WEST SUSSEX COUNTY COUNCIL CONSULTATION

TO:	Arun District Council FAO: Anita Gardner
FROM:	Highways, WSCC
DATE:	17/01/2018
LOCATION:	Windsong, The Thatchway, Rustington, BN16 2BN
SUBJECT:	R/306/18/PL Demolition of the existing dwelling & erection of 1 No. 3-bedroom one and a half storey dwelling. This application may affect a Public Right of Way.
DATE OF SITE VISIT:	N/A
RECOMMENDATION:	☒ Advice ☐ Objection ☐ Modification ☐ No Objection ☐ More Information ☐ Refusal
S106 CONTRIBUTION TOTAL:	£N/A

SCANDIA-HUS BUSINESS PARK, FELCOURT ROAD, FELCOURT, EAST GRINSTEAD, WEST SUSSEX, RH19 2LP : TEL 01342 838060		
FOR MR & MRS MOOR		
SITE WINDSONG, THE THATCHWAY, RUSTINGTON, BN16 2BN		
TITLE PROPOSED SITE PLAN		
C/No. 222858	O/No.	SCALE 1/200 @ A2
DRAWN FC		DRAWING NUMBER SP02
DATE 06/18		
		REV

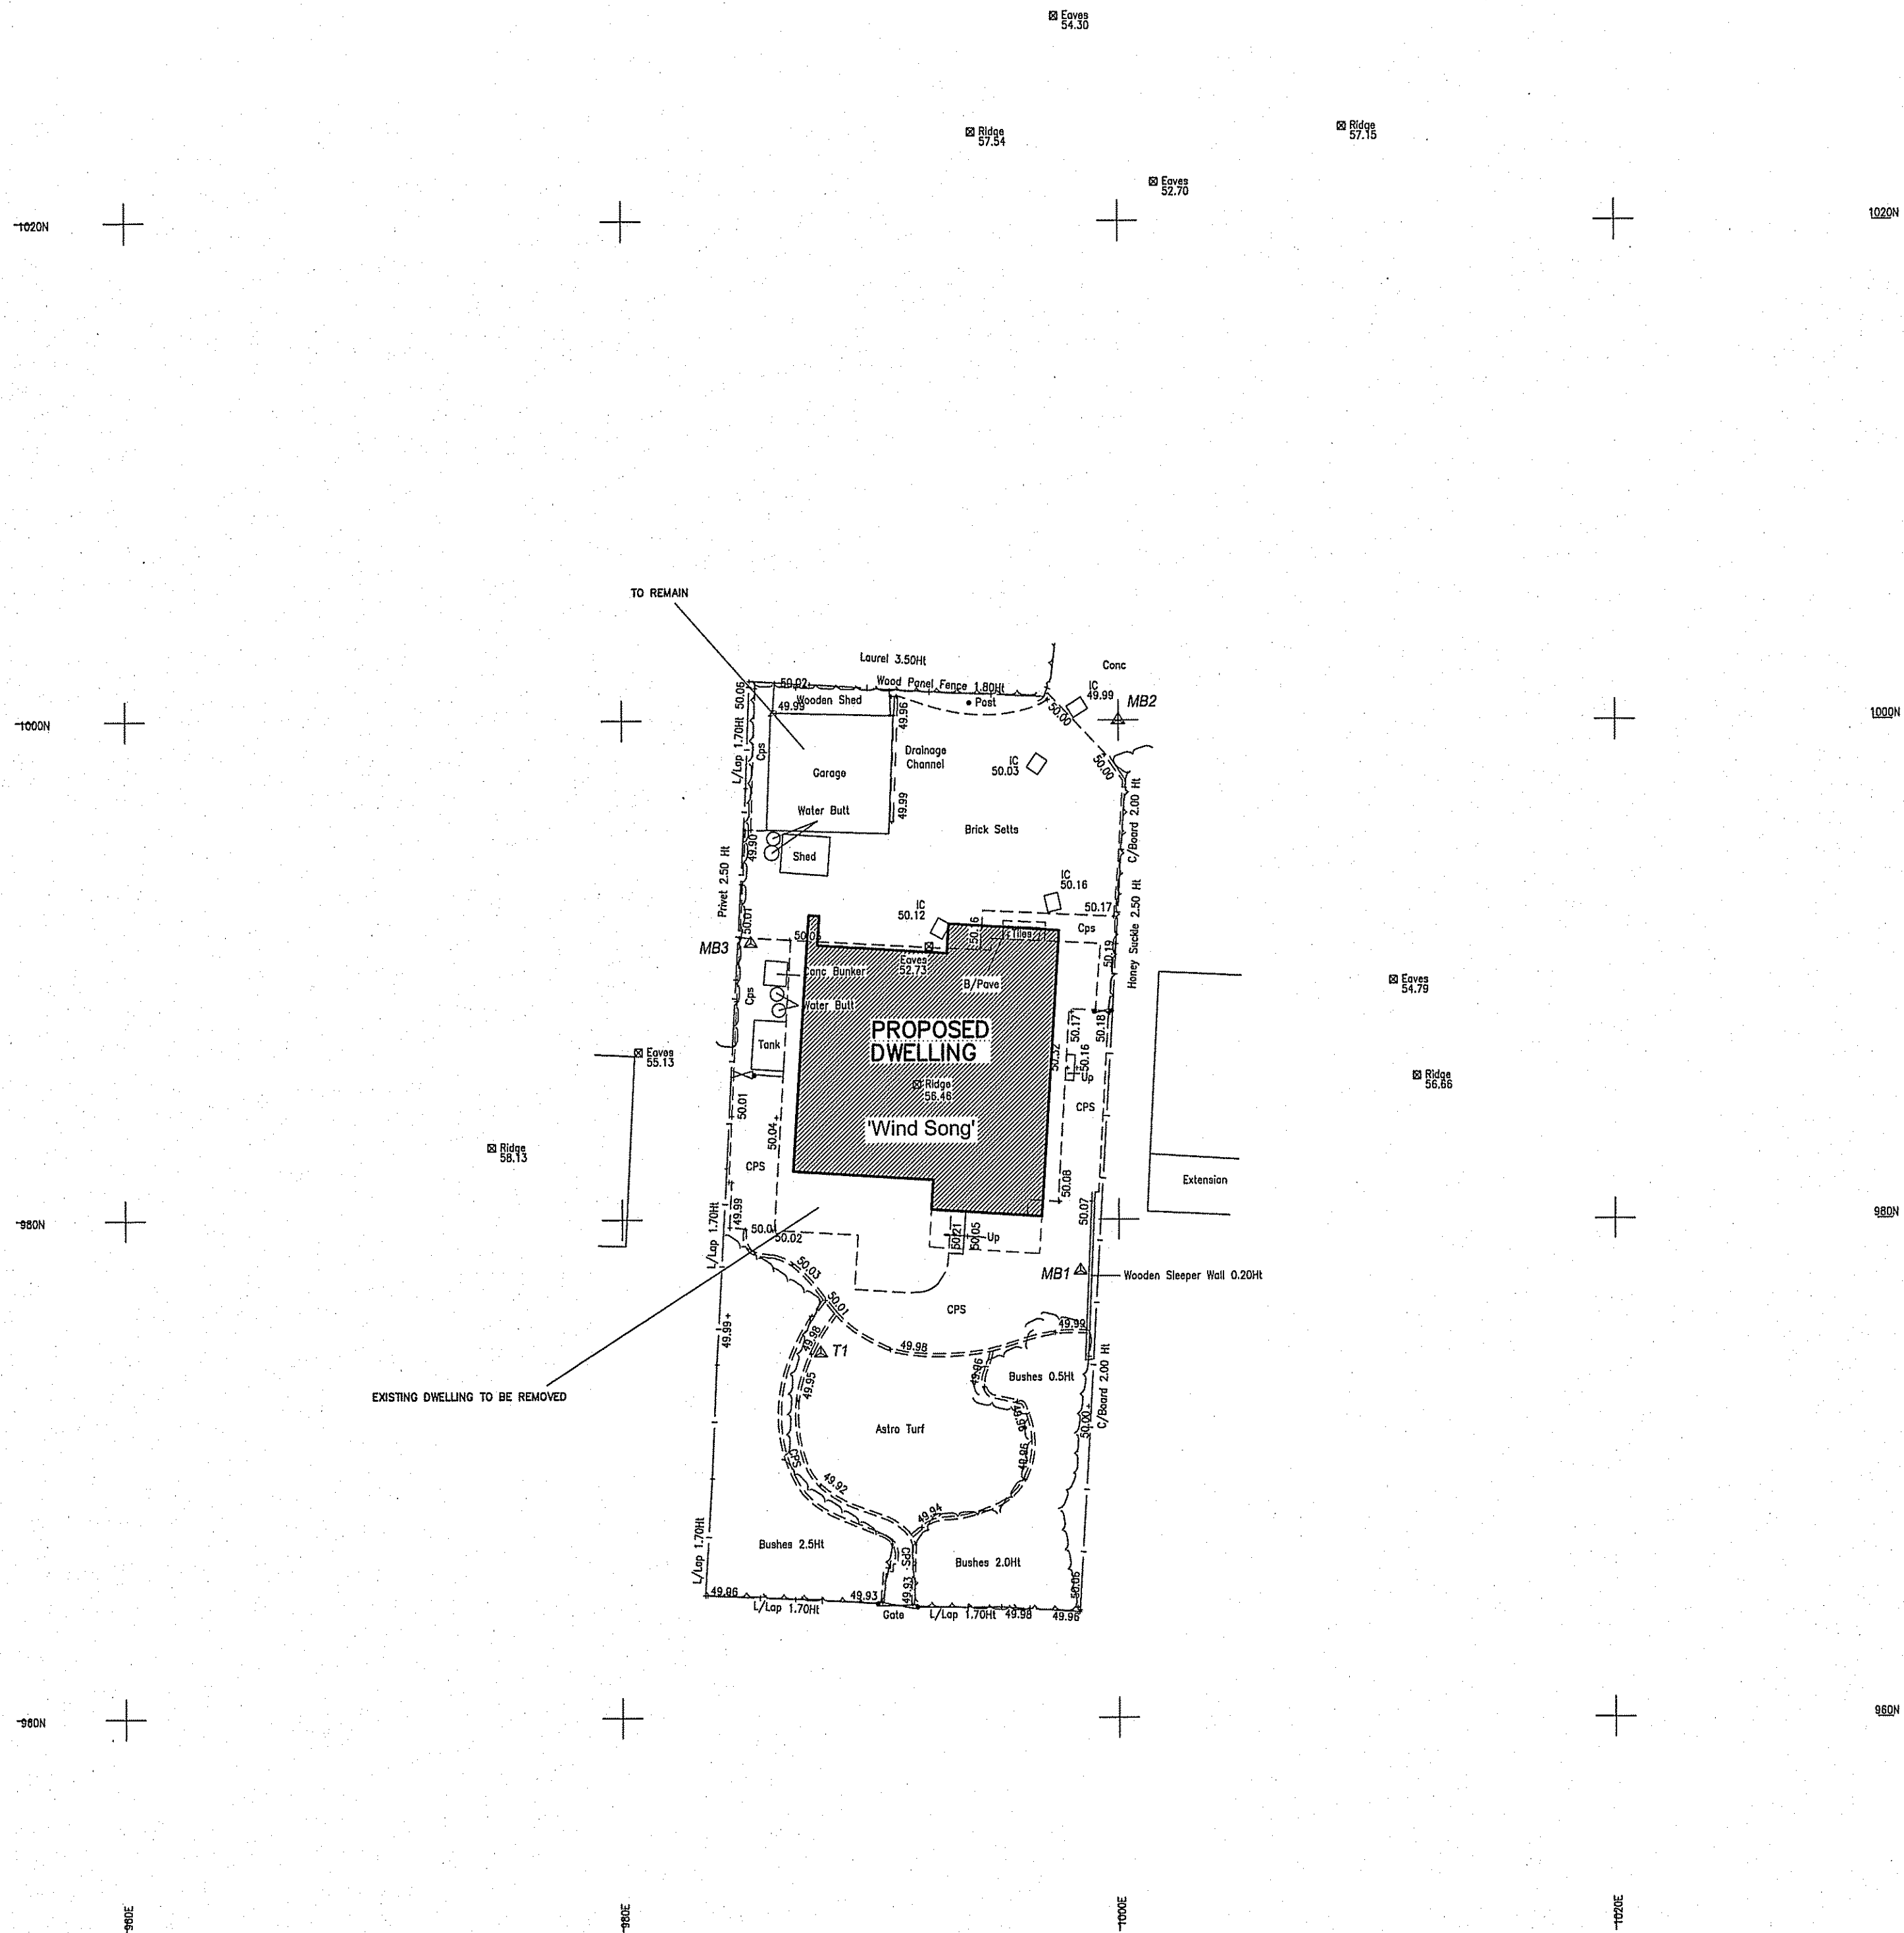
The proposed plans indicate that the existing double garage and hardstanding parking area will be retained, providing sufficient space for vehicles to park for the residential use. There appears to be sufficient space on site for vehicles to turn on site.
